# CITY OF ALBUQUERQUE

December 21, 2016

**Re: Bombs Away Beer Co.**  
**9801 Acoma Rd SE**  
**Traffic Circulation Layout**  
Architect's Stamp XX-XX-XX (L20-D070)

SITE PLAN / PARKING

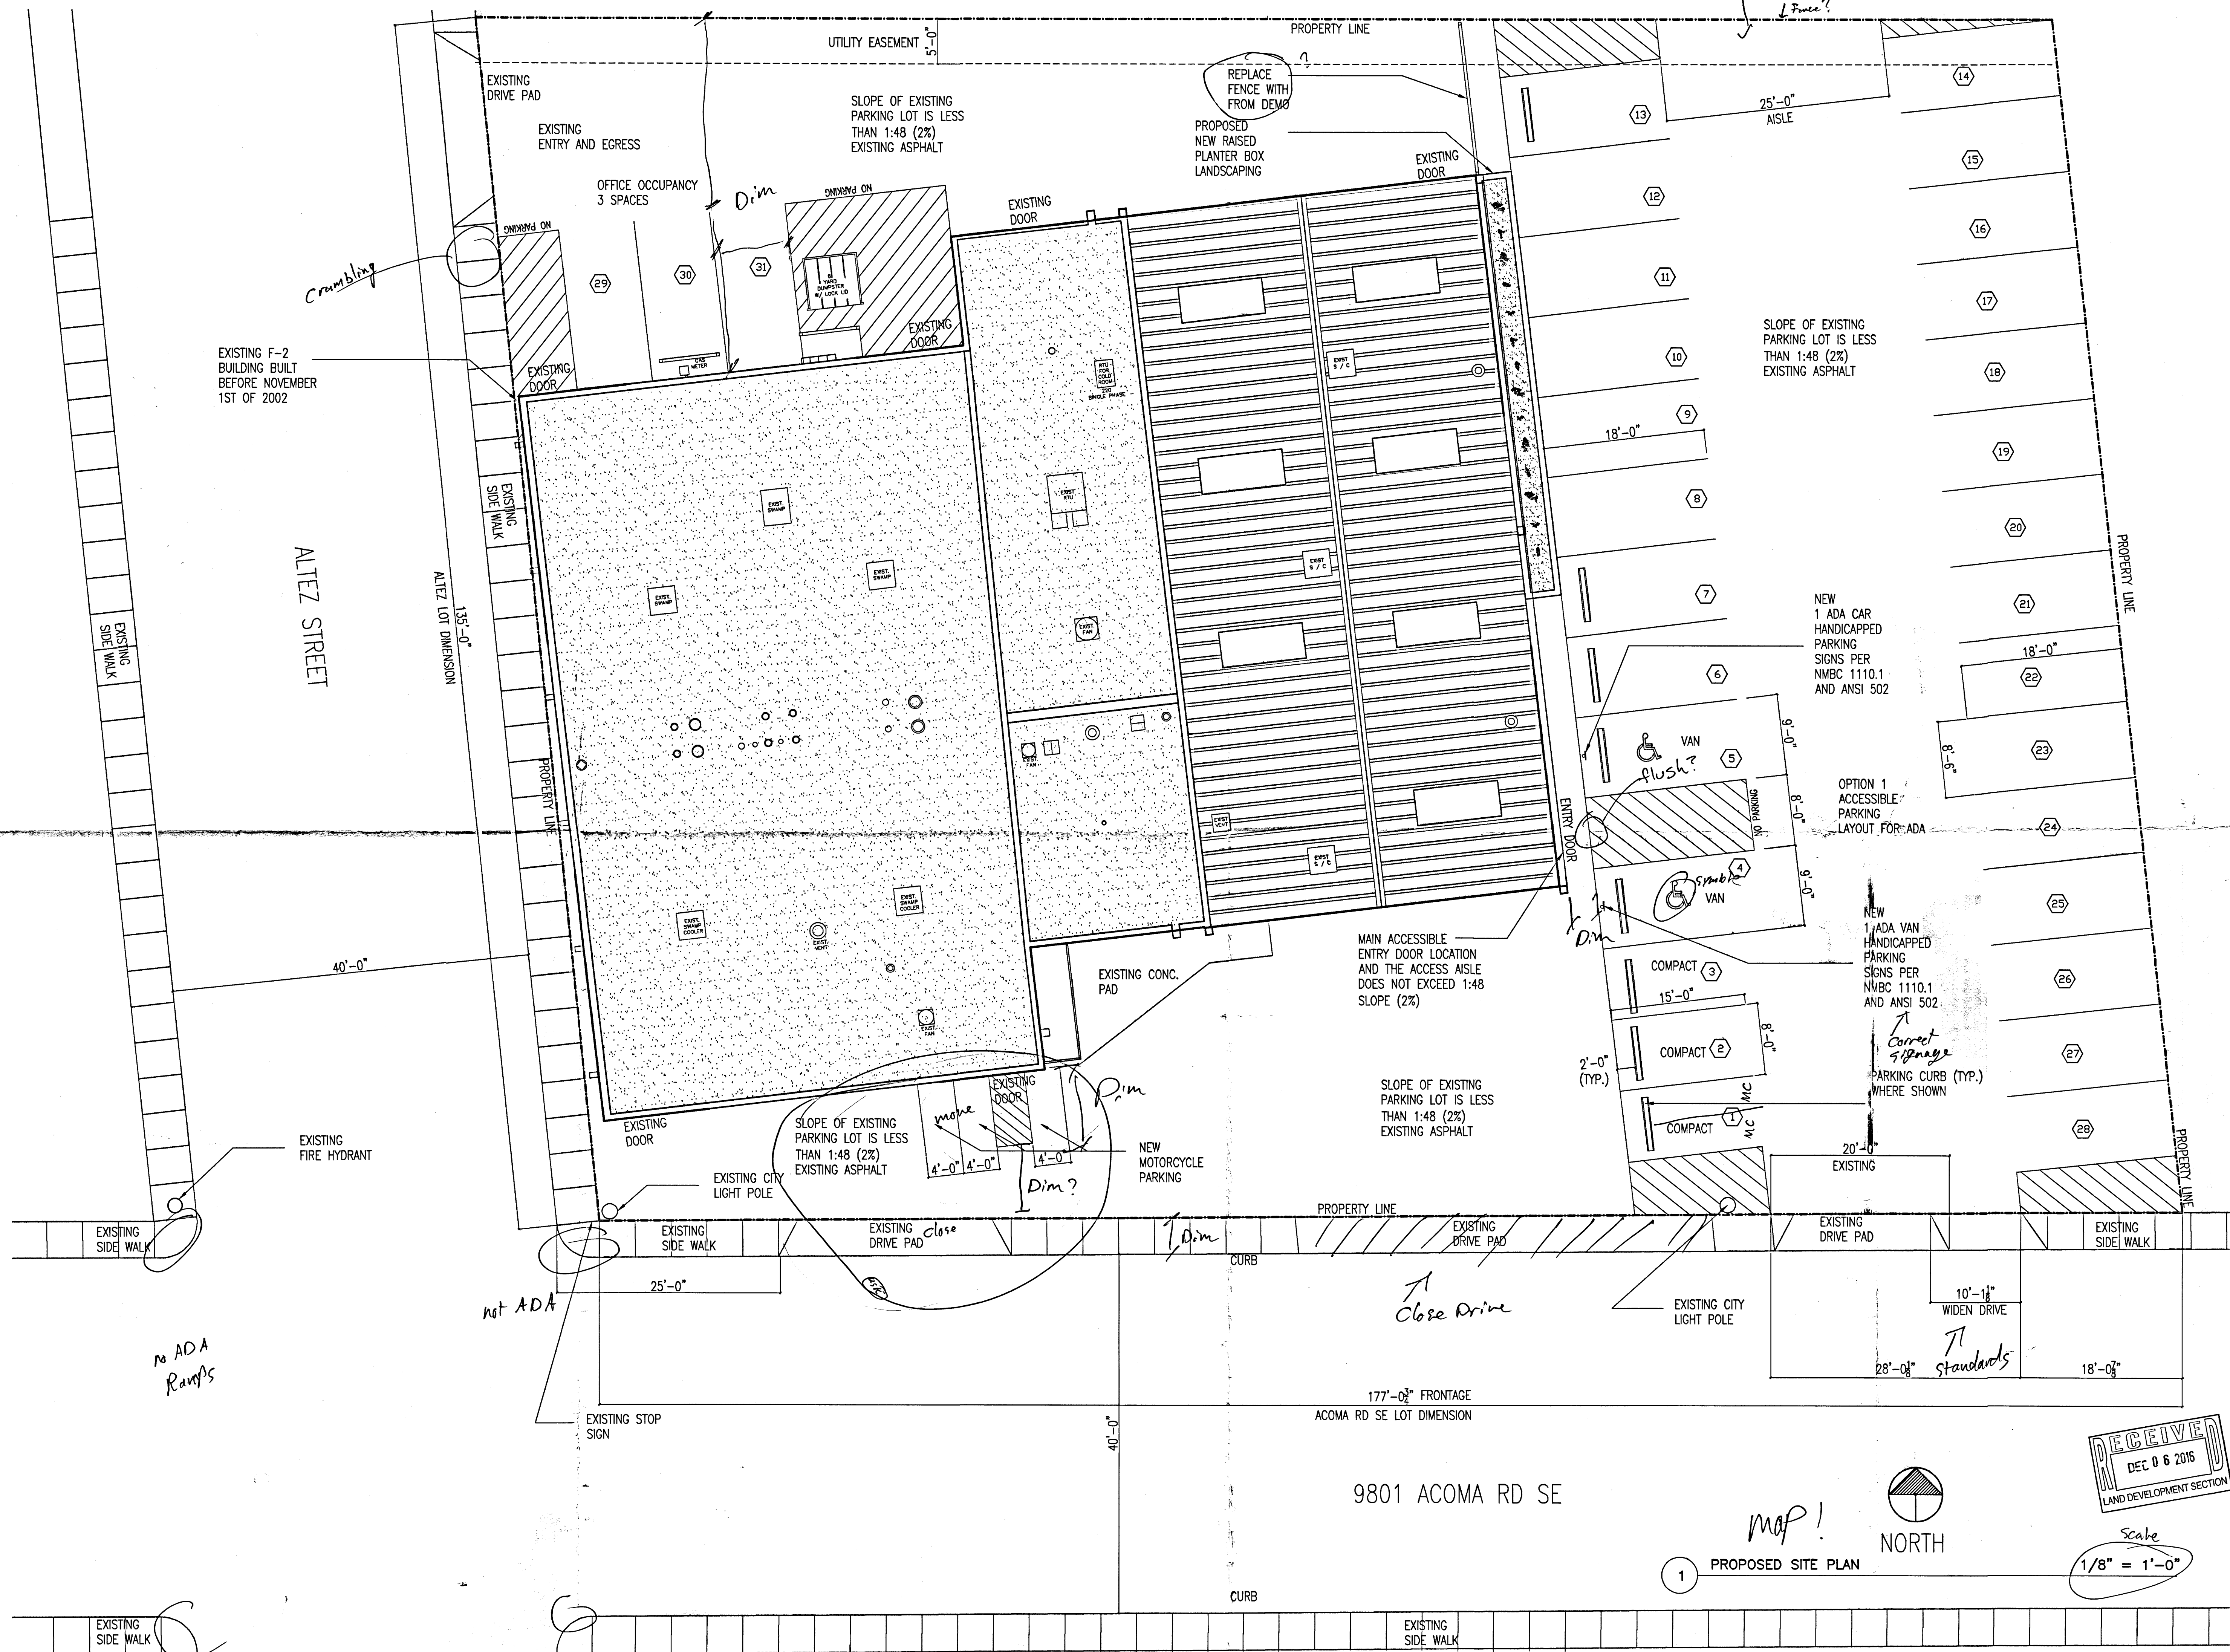
1. Please show a vicinity map showing the location of the development in relation to streets and well known landmarks.
2. A scale of 1"=20' is recommended for sites less than 5 acres per the Development Process Manual, Chapter 27, Section 2, Part B.1.

3. The traffic circulation layout must be stamped, signed, and dated by an engineer or architect licensed in the state of New Mexico.
4. Please identify all existing drive pad widths.

5. Please list the width and length for all existing and proposed parking spaces. Some dimensions are not shown. What are the dimensions of the parking stall in the back?

6. Label the compact parking spaces by placing the words "**COMPACT**" on the pavement of each space.
7. The ADA accessible parking sign must have the required language per 66-7-352.4C NMSA 1978 "**Violators Are Subject to a Fine and/or Towing.**" Please call out detail and location of HC signs.

8. The ADA parking space has a clearly visible, blue, International Symbol of Accessibility painted on the pavement at rear of the space (66-1-4.1.E NMSA 1978) or MUTCD recommends a white symbol on a blue background.

9. Show all drive aisle widths and radii. Some dimensions are not shown. Please dimension the distance from the parking stalls in the back to the end of the drive aisle, also dimension the aisle for the motorcycle parking.

10. Per the zoning code, a 6 ft. wide ADA accessible pedestrian pathway is required from the public sidewalk to the building entrances. Please clearly show this pathway and provide details or notes if it is flush with the entrance.

11. Per DPM, a 6 ft. wide ADA accessible pedestrian pathway is required from the HC parking stall access aisles to the building entrances. Please clearly show this pathway and provide details.
12. Please specify the City Standard Drawing Number when applicable.
13. Unused curb cuts must be replaced with sidewalk and curb & gutter. A build note must be provided referring to the appropriate City Standard drawing.
14. The second driveway on Acoma Rd must be closed. Please relocate the motorcycle and close the NW driveway on Acoma RD.
15. Add a note stating "All broken or cracked sidewalk must be replaced with sidewalk and curb & gutter." A build note must be provided referring to the appropriate City Standard drawing.
